Recommendation Report for Planning Permission for Works or Extension to a Dwelling

REF NO: M/100/24/HH

LOCATION: 1 Elmer Court
Elmer
Middleton-on-Sea
PO22 6JT

PROPOSAL: Single storey rear pergola and first floor rear balcony with sliding doors. (Part retrospective).

06 SIDE (EAST) ELEVATION:

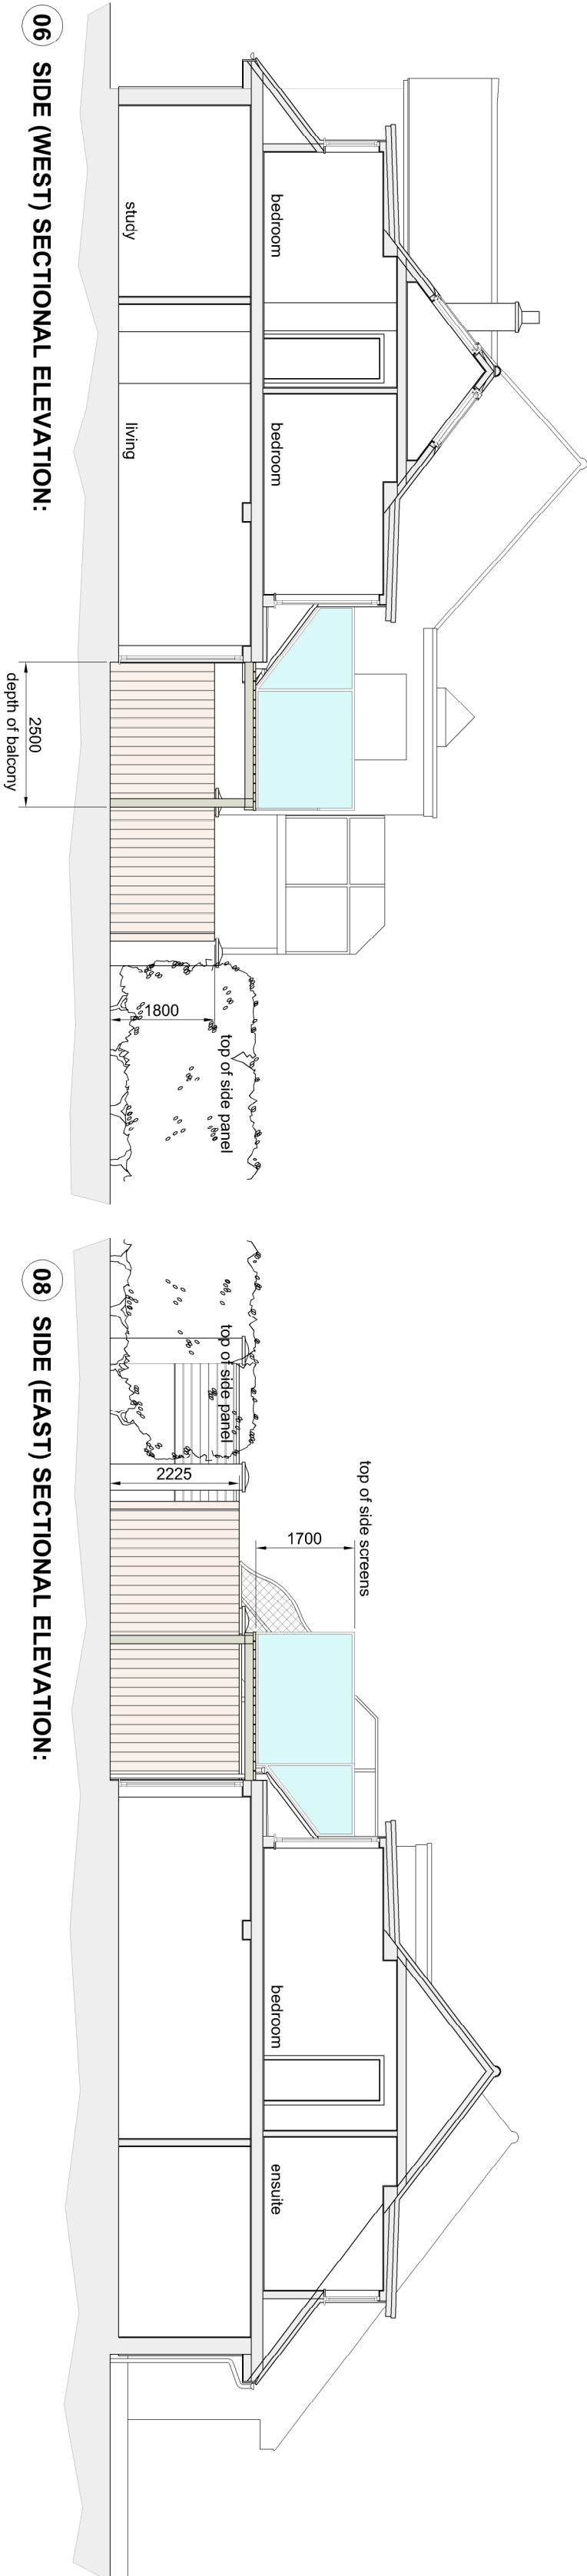
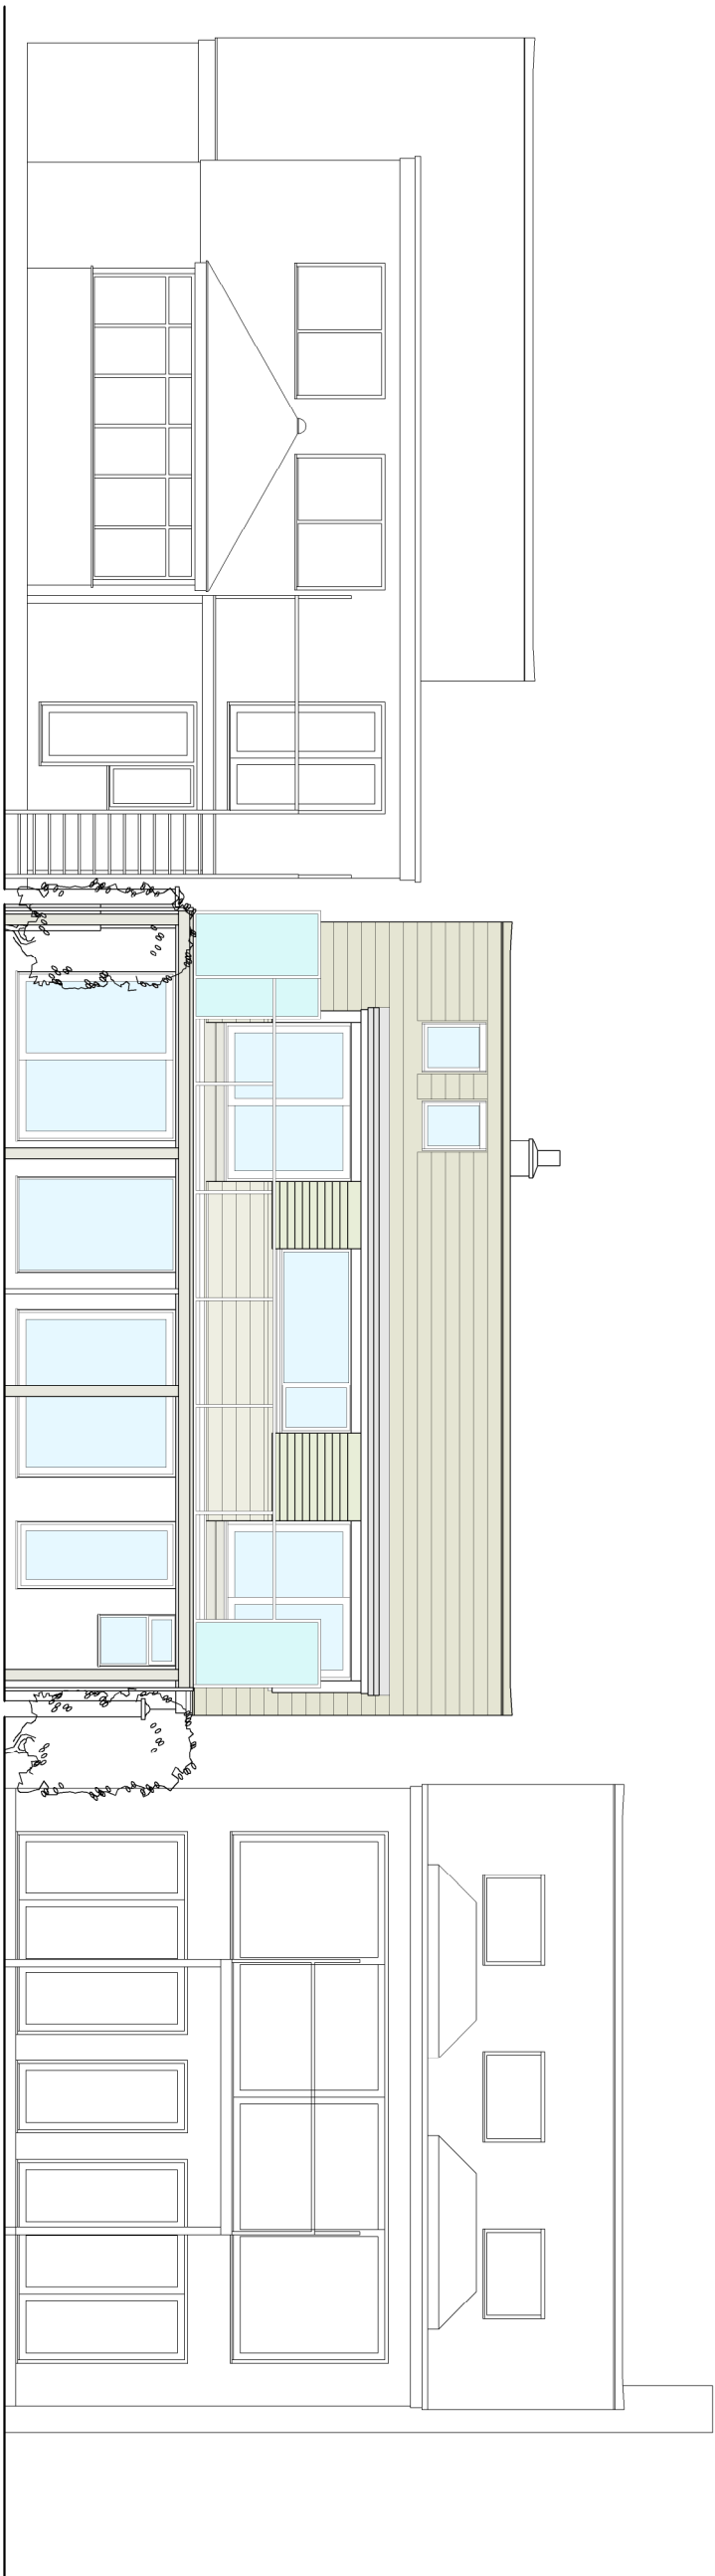
The balcony would measure 5m in depth and it would extend along the entire width of the dwelling (approx. 11.2m). It is noted that there are 2 sets of casement windows to the rear elevation of the house which serve the bedrooms of the property. It is proposed to increase the windows serving the bedrooms to allow for 2 sets of patio doors. Objections have been received from nearby occupiers stating that the proposal would be out of character with the area and that the scale of the proposal is overbearing. On discussion, plans were amended to reduce the depth of the balcony to 2.7m.

It is accepted that the amended plans would be an improvement on what was initially proposed. Due to the submission of inaccurate site plans it is not possible to fully and accurately assess the impact of the development on the host dwelling or wider area. A 1.8m wood panel side screening is proposed at first floor level, the wooden panelling will appear extremely overbearing in its context and will alter the character of rear elevation of the dwelling significantly.

In terms of overlooking, the first-floor balcony by virtue of its size and location when in use will give rise to significant overlooking of neighbouring properties. The balcony will offer direct views into the rear gardens of neighbouring properties. To counter this, a 1.8m high wooden panelling is proposed on both sides (east and west) to protect the residential amenities of neighbours and mitigate any overlooking. However, this screening would result in a scheme detrimental to the character and appearance of the host dwelling contrary to D DM4 of the Arun Local Plan (ALP).

The two sets of patio doors proposed on the rear (south) elevation at first floor level will not have any additional overlooking impact as these are proposed in the same location as additional windows and are acceptable.
